Stage 1 RSA - Road Safety Audit Addendum Response Report [Rev P1]

North Littlehampton, Phase 2 comprising Parcel C1 and Part Parcel B2, B4 and C2

Stage 1 RSA – Road Safety Audit Addendum (2) Response Report

Date: 7 December 2017

GENERAL ARRANGMENT DRAWING (1 OF 2)

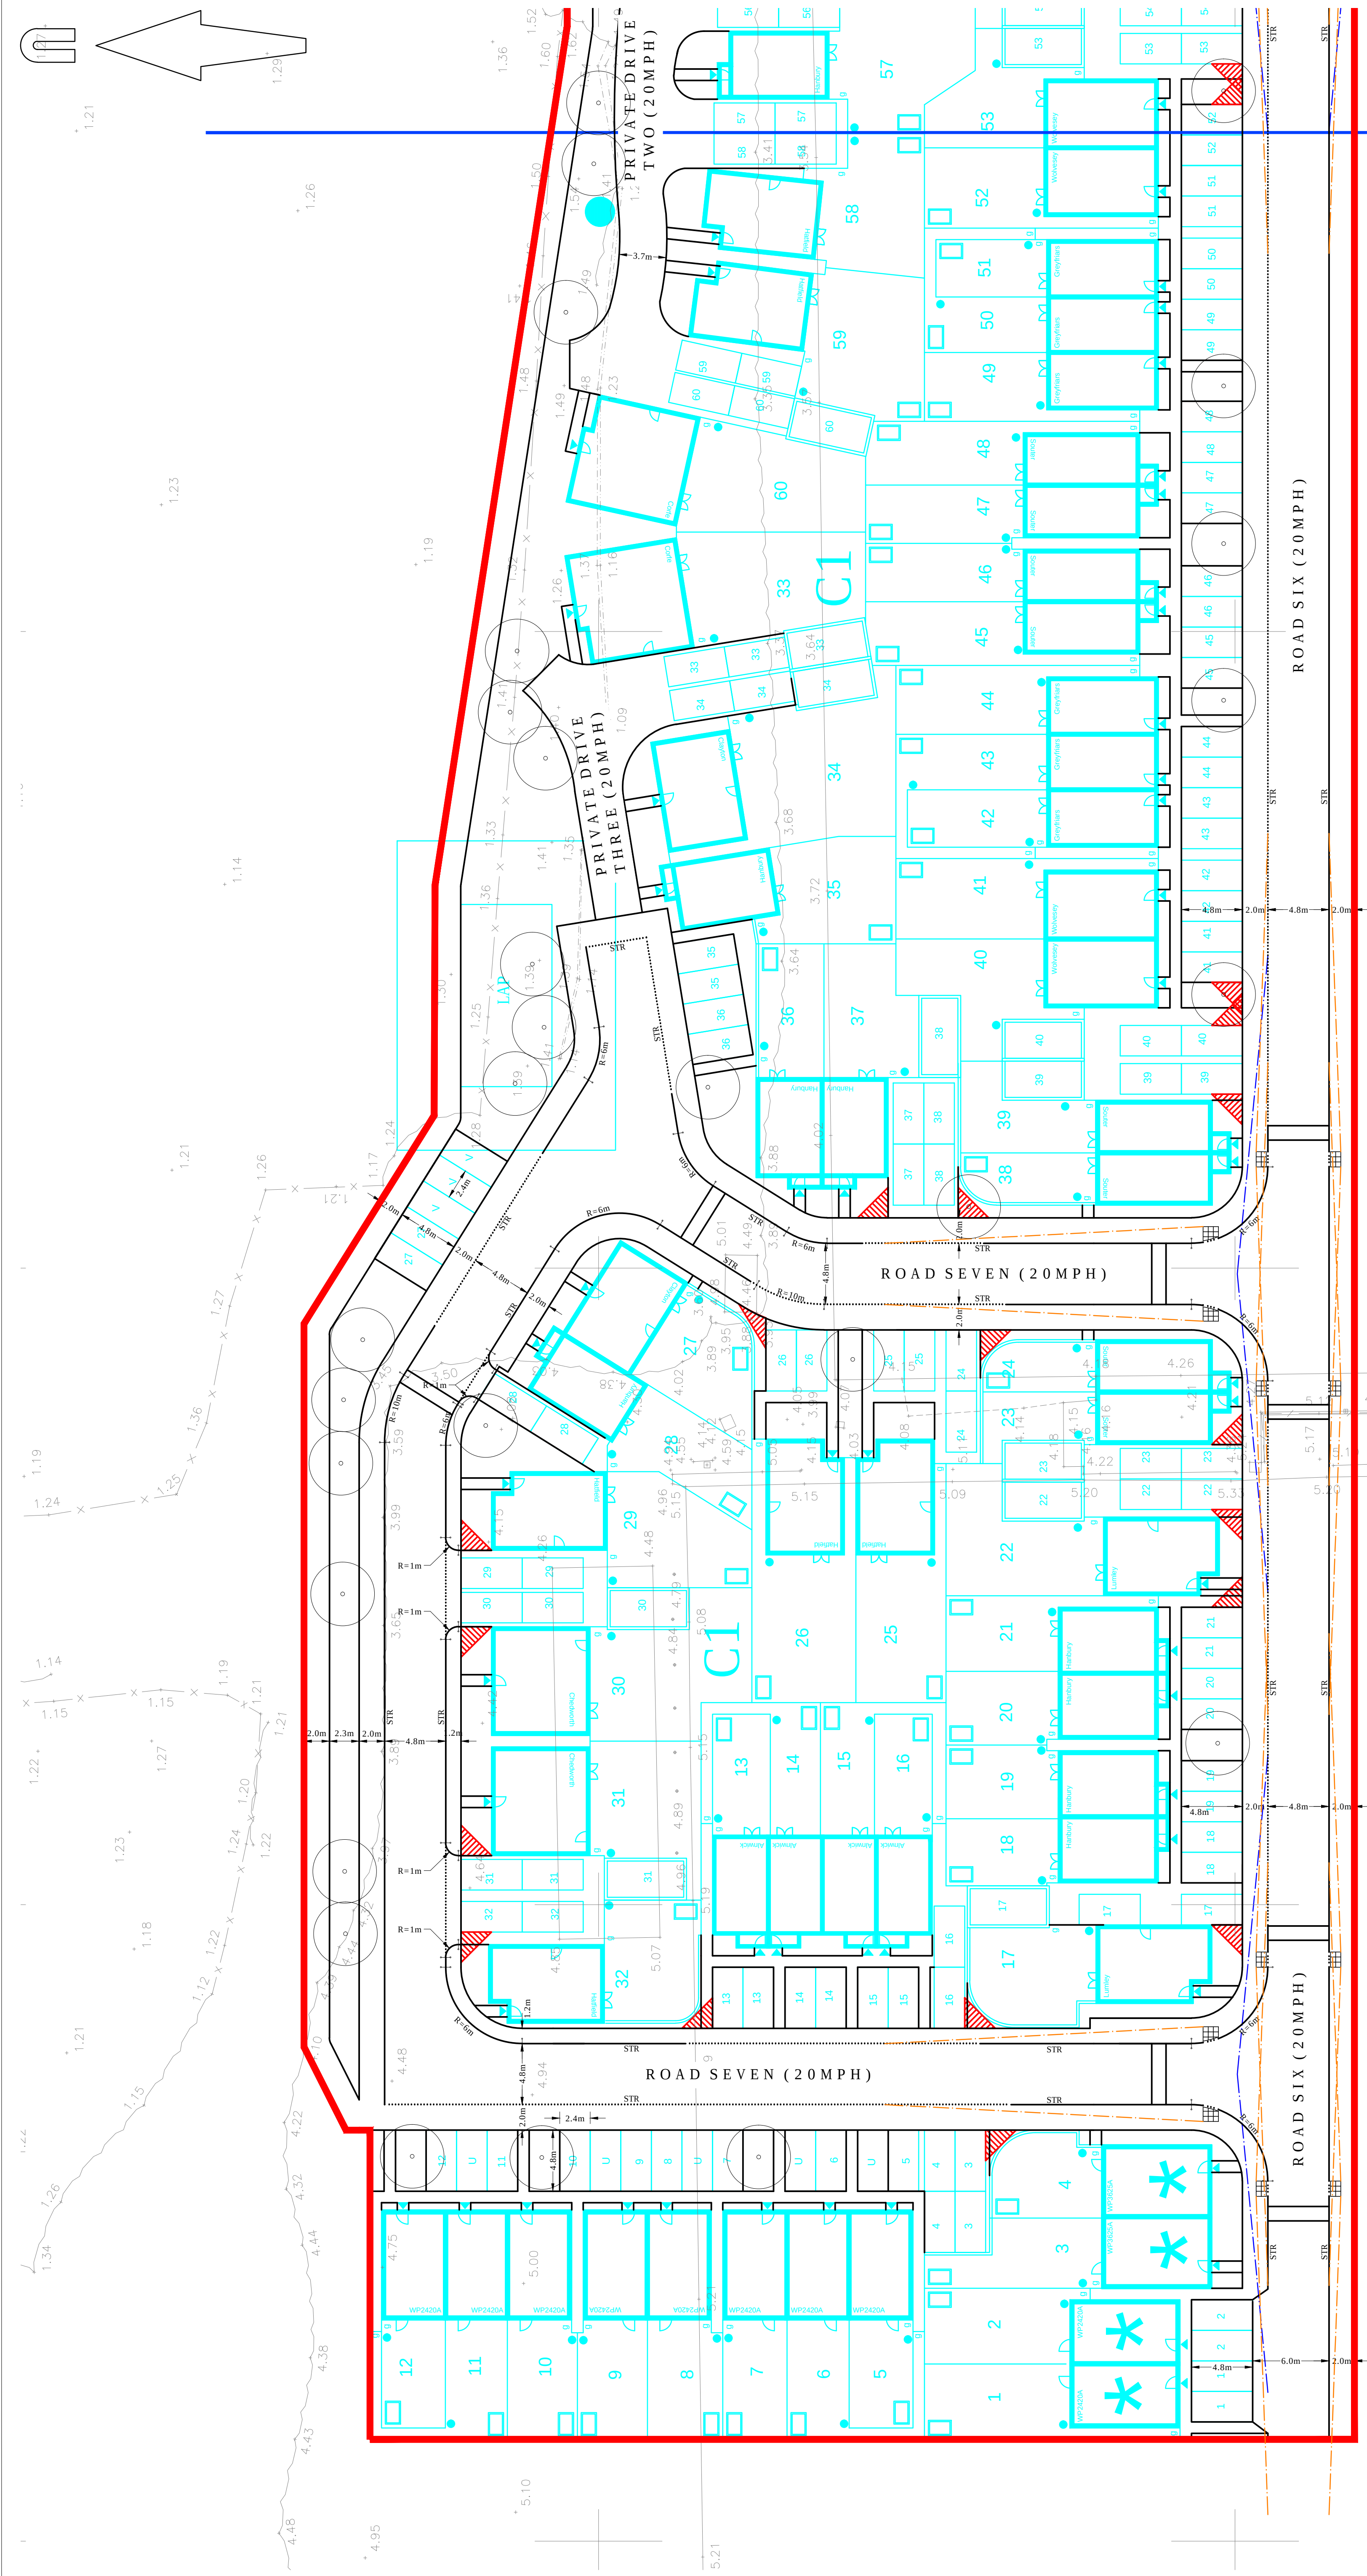
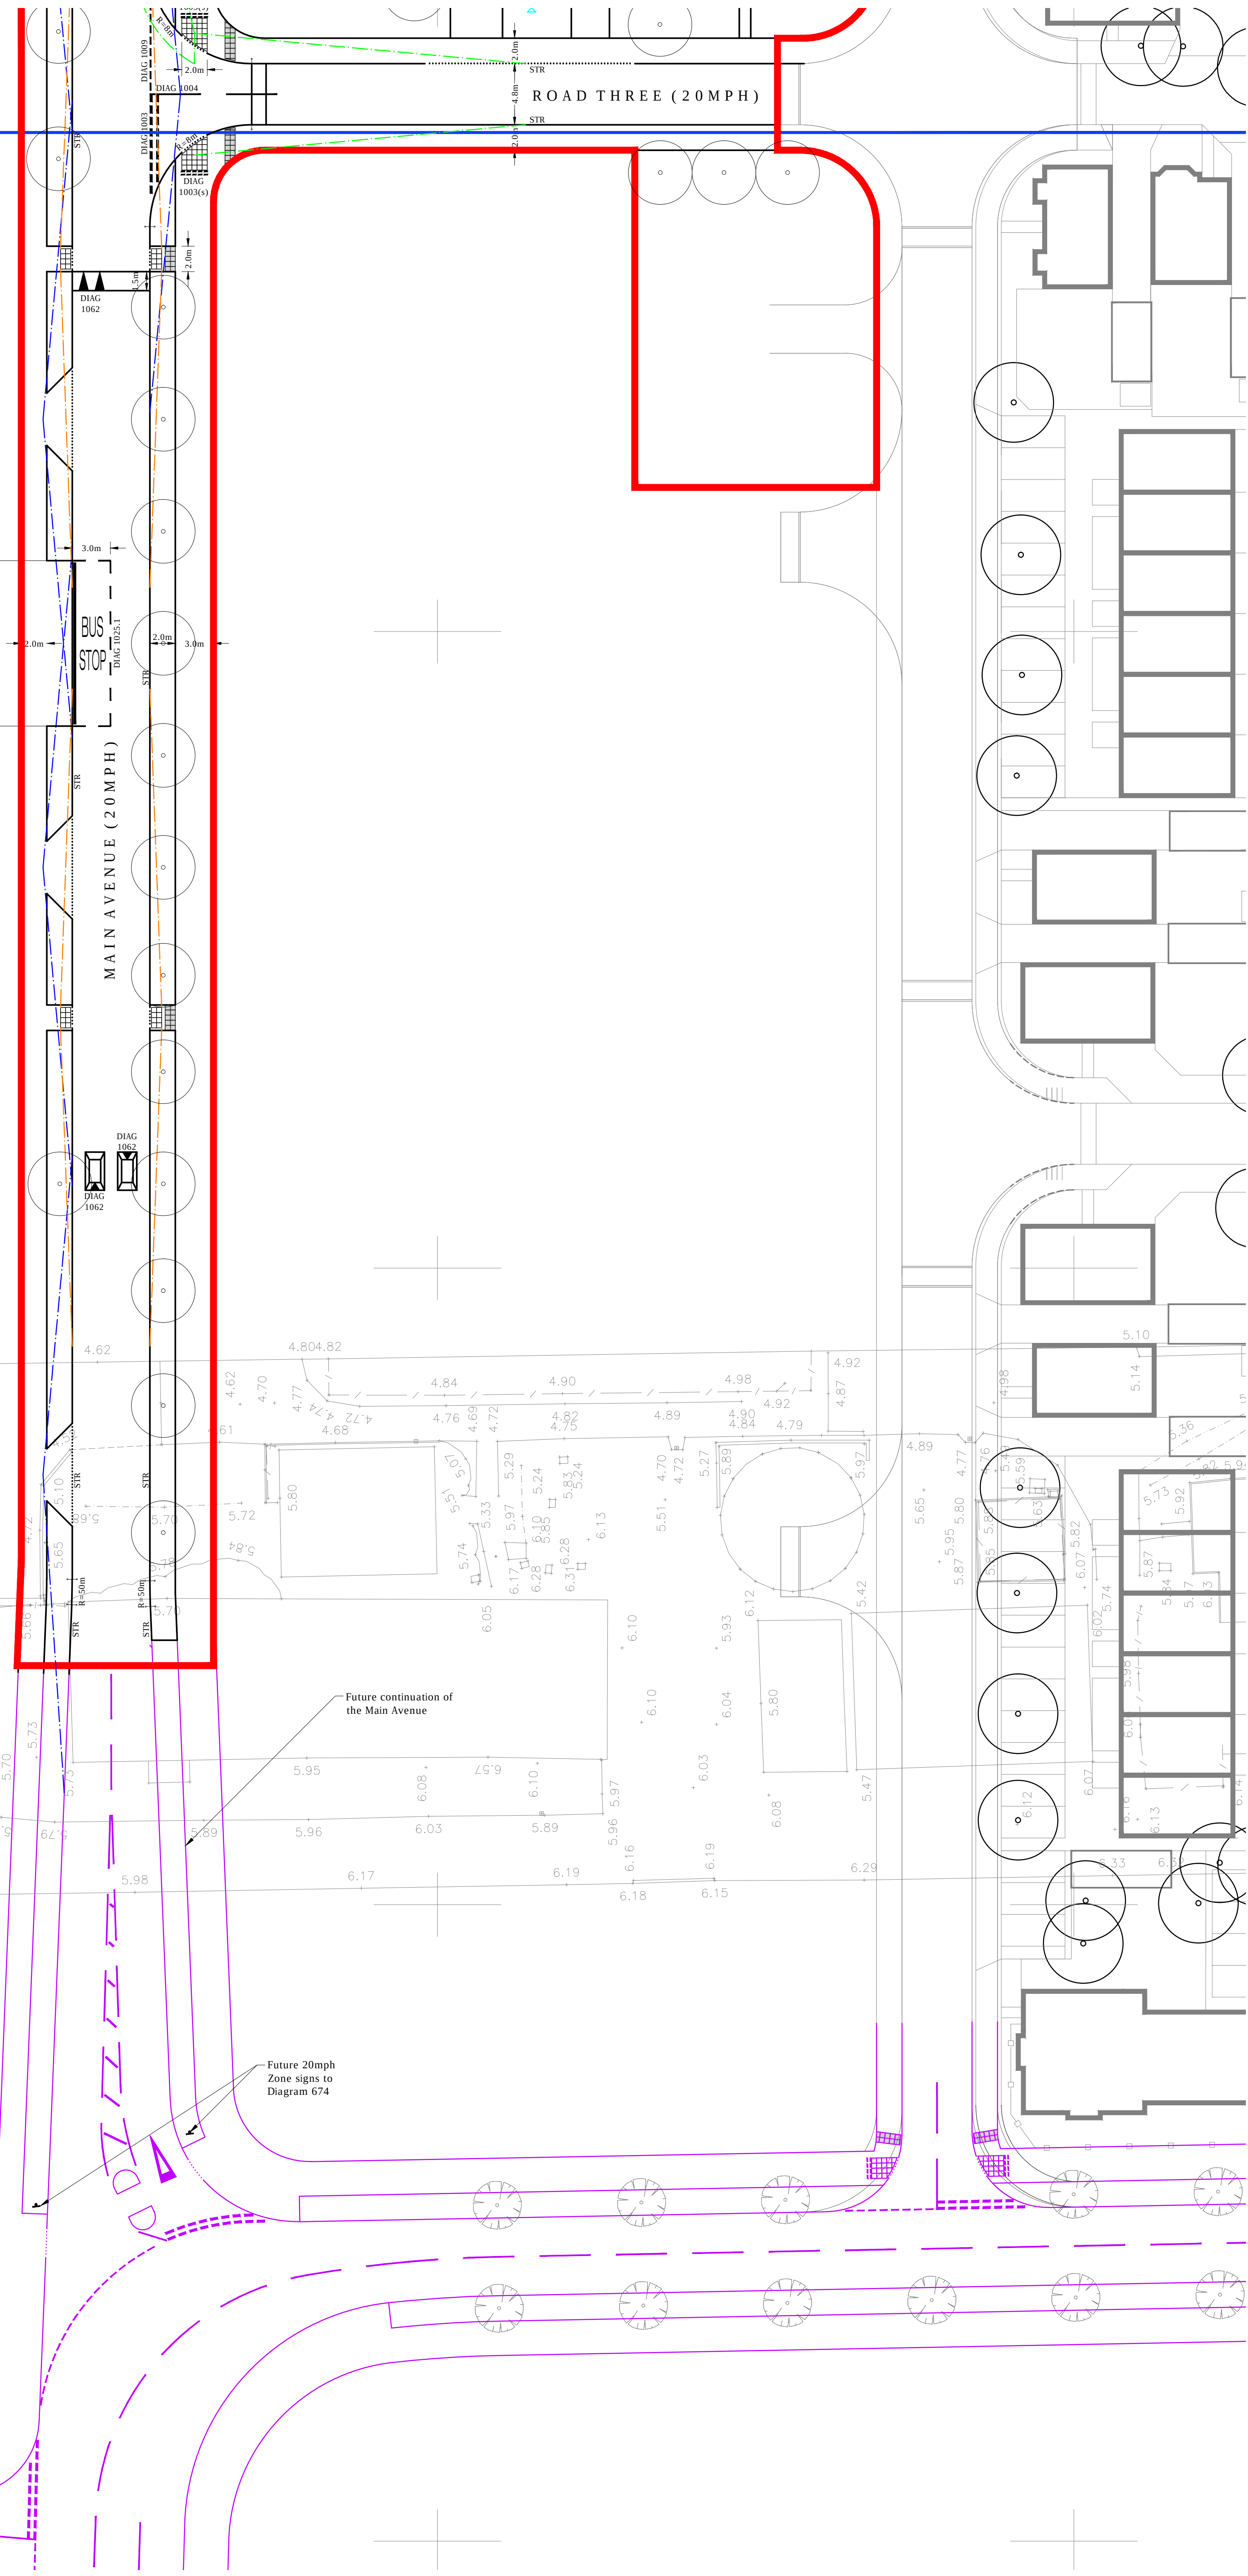
Item	Problem	Recommendation	Designer's Response
3.1	Location: General Summary: Visibility splays Whilst some visibility splays have been formally identified on the drawings submitted, it will be important that all visibility splays remain free from obstruction. It is noted that some visibility splays extend across / through 3rd party land, cycle storage areas or parking bays (on 3rd party land). A number of trees are shown within the verges of the development site, some of which appear to be within the junction visibility splays. Even if the trees are intended to be of relatively small girth and have clear stems, they will inevitably have some impact on sightlines; this effect will be greater the closer they are to the junction and will increase with time as the trees grow. This will increase the risks of vehicles emerging from the side roads being struck by passing traffic.	i. Provide visibility splays in accordance with relevant design standards and ensure that the splays will be kept free from obstruction. ii. Any vegetation within the splays should be maintained to ensure that it does not extend beyond a vertical height of 0.6m. iii. Do not plant trees within the visibility splays.	(i) - Visibility splays have been indicated in accordance with design standards as recommended. On inspection the radii on approach to the pedestrian visibility splays adjacent to the Motorcycle Parking and the Pedal Cycle Parking bays (near dwelling 36) are a maximum of 18m. Thus calculating curve design speed it can be determined that an 18m radius translates to a vehicle speed of just over 23 km/h. Thus in accordance with MfS Table 7.1, this corresponds to a Stopping Site Distance of 17m. Thus the visibility splays have been adjusted to indicate this and now do not encroach on the cycle or motor cycle parking areas. In relation to the car parking associated with Dwelling 31, this has been moved backwards to avoid parked cars obstructed visibility. Furthermore, PHTV has confirmed that the development will be run by a management company and it will be made clear that all visibility splays are to be kept clear of obstructions (other than the street trees). (ii) – PHTV has confirmed that the development shall be run by a management company and any vegetation shall be maintained as required. (iii) – Trees within visibility splays are required along the Main Avenue to create the tree lined street effect and therefore, an Exception to this 'Problem' will be required.
